Stadium Australia- SSD10342- Stormwater Management

SUBJECT: Stadium Australia Redevelopment
Civil Works-Stormwater Drainage Report – ADDENDUM 1

Stadium Australia Redevelopment (SAR)

Civil Works-Stormwater Drainage Report – ADDENDUM 1

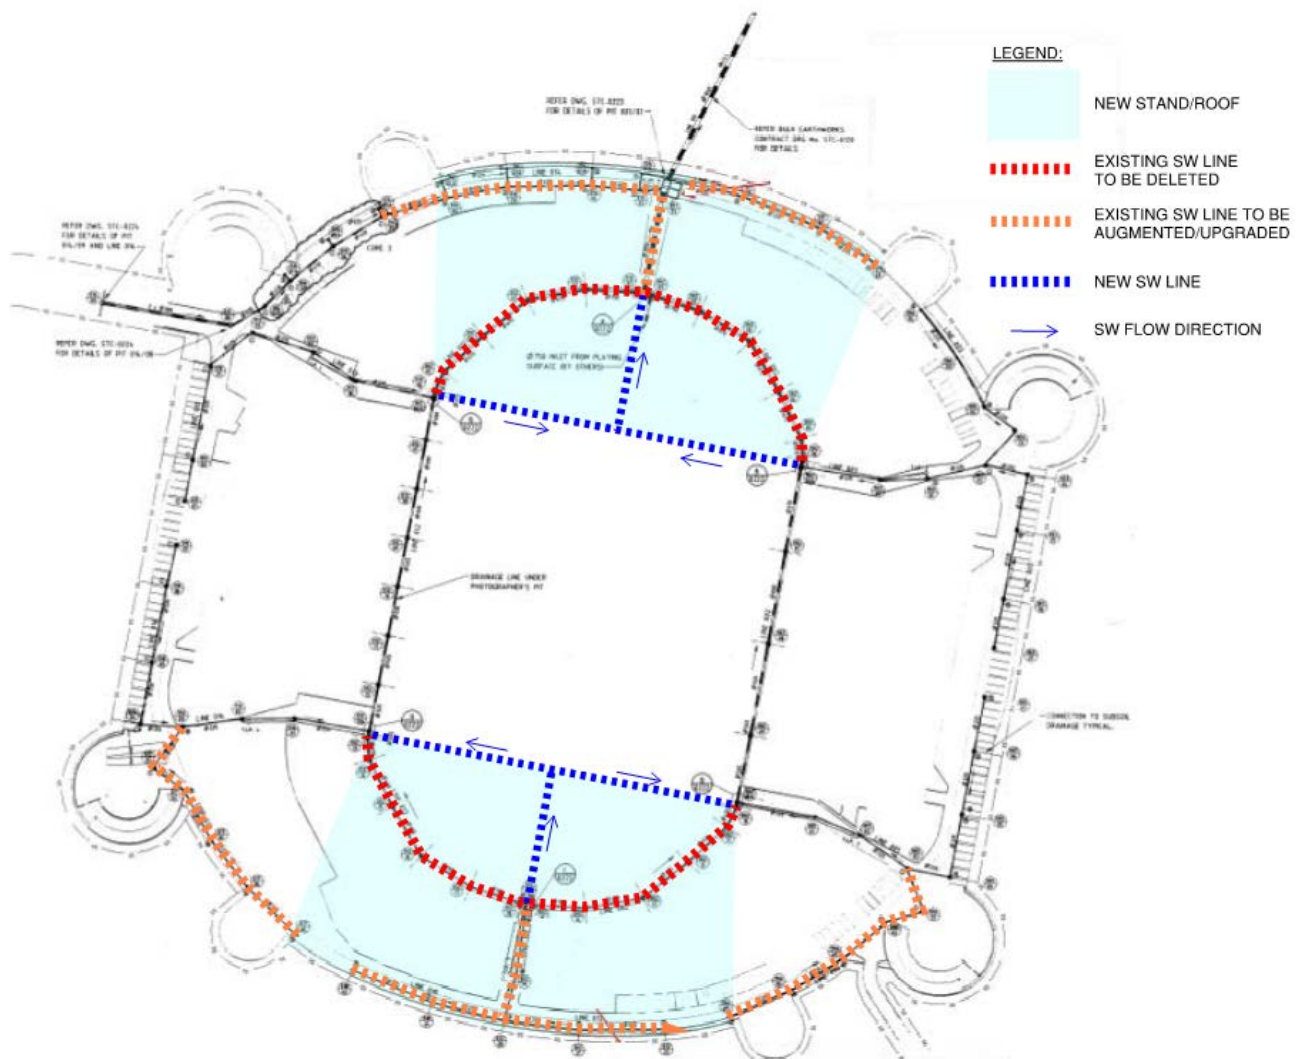
The Addendum highlights that the Aurecon 'Stormwater Management Plan' dated 16th August 2019 (Aurecon reference 255576), in regards to the submitted design, is in error when it states in its

Section 3.1

- *'...the stadium's stormwater drainage under the northern and southern stands where it is envisaged that the existing under-stand drainage system will be removed and replaced with a new in-ground network...*
- *'...On-site detention will no longer be provided under the stands for major storm event but would rather temporary overflow on to the field before draining out...'*

The letter from Maffei Engineering corrects an error in the Stormwater Management Plan lodged with the EIS that stated existing detention areas under the north and south stands would be removed as a result of the works. These detention areas will be retained and augmented as part of the project works to ensure there is no change to stormwater flows from the site.

- The stormwater detention basins provided in the design cater for 100% of the volume of the stormwater detention required.
- The field of play is not designed to be flooded during the required storm events.
- The Maffeis Engineering design will maintain stormwater detention under the North & South Stands and, further, provides increased detention volume.
- The submitted 'Civil Works-Stormwater Drainage Layout' drawing SAR-SD-20-0100-02 identifies stormwater detention basin locations and required storage volumes to meet the design stormwater detention requirement.
- The maximum discharge rate from the site following completion of the works is unchanged from what is currently the discharge rate including for the 100 year ARI event.
